North Lincolnshire Green Energy Park

9.7 Schedule of Changes to Book of
Reference and Land Plans

PINS reference: EN010116

Revision number: 2

| Drawing No: NLGEP-ARD-XX-XX-DR-Z-0002 | |

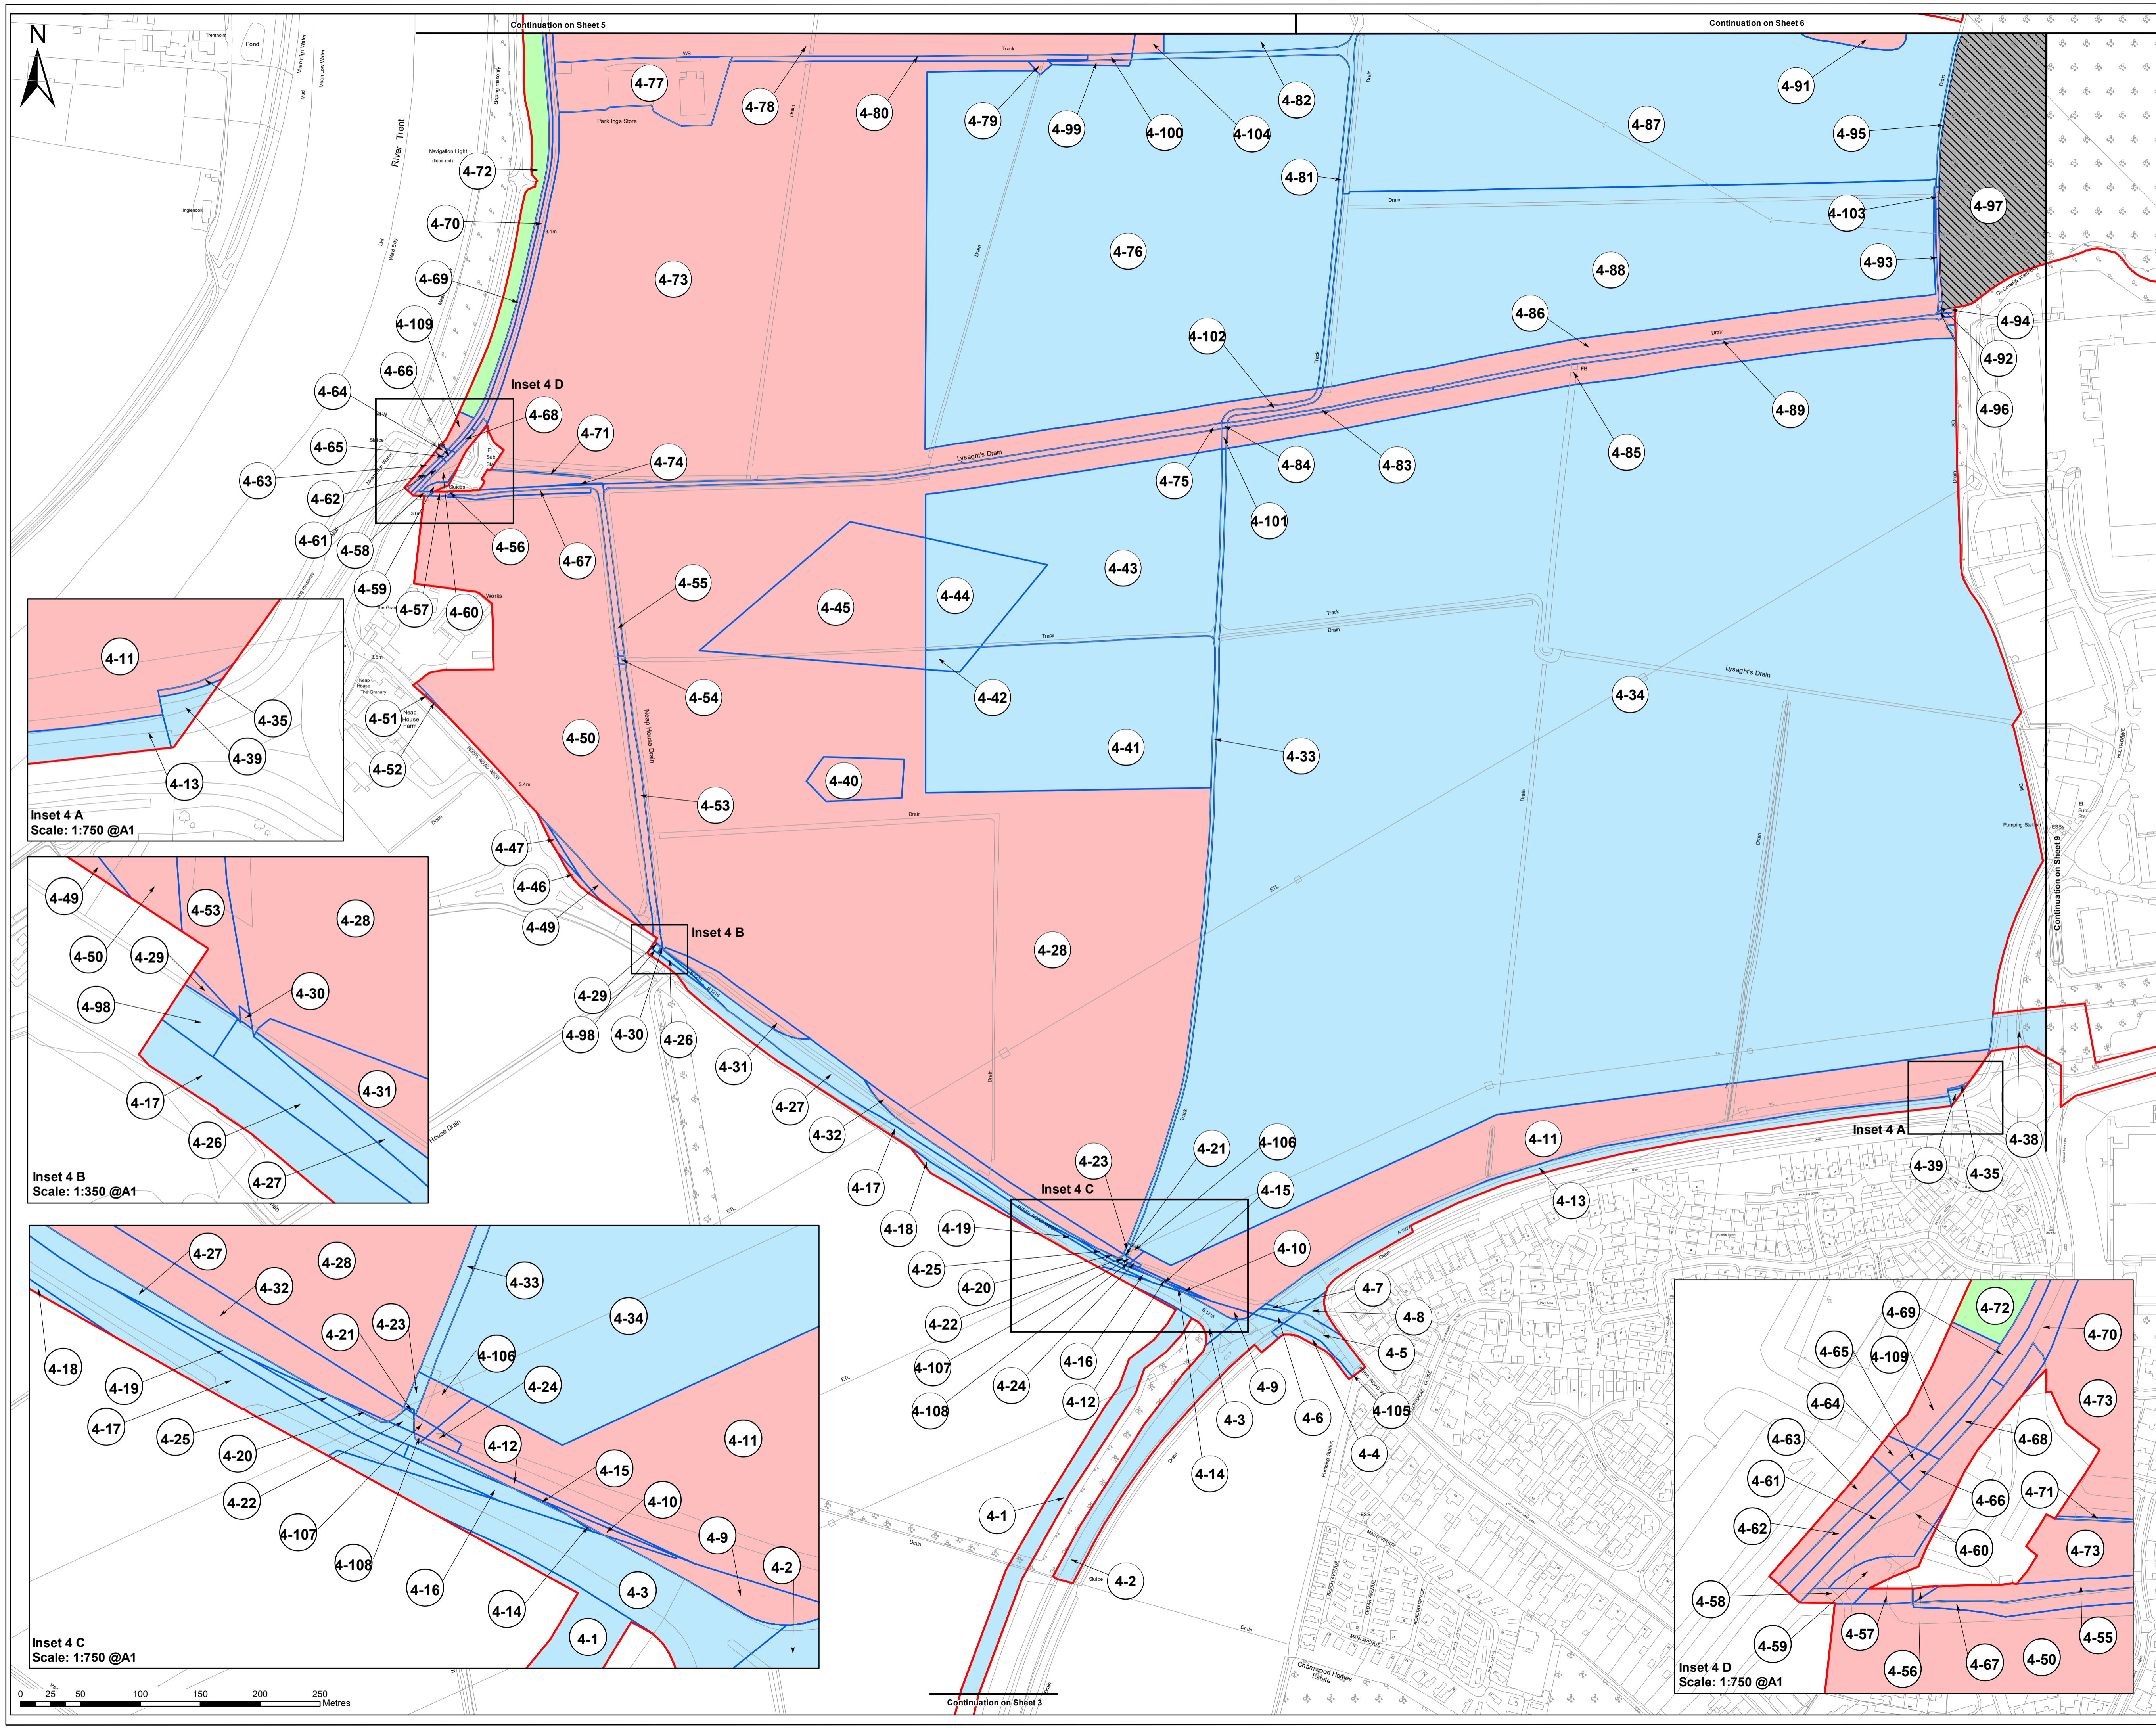
4.2 Land Plans	Created larger inset on sheet 4 for plots 4-92, 4-93, 4-94, 4-96, 4-97, 4-103.	Requested by Examiner.	4-92 4-93 4-94 4-96 4-97 4-103
3.1 Book of Reference	Northern Powergrid (Yorkshire) Plc's apparatus interest on plot 10-64 has been moved from cat 1 column to cat 2.	Consistency check. Apparatus should be cat 2 and not cat 1.	10-64
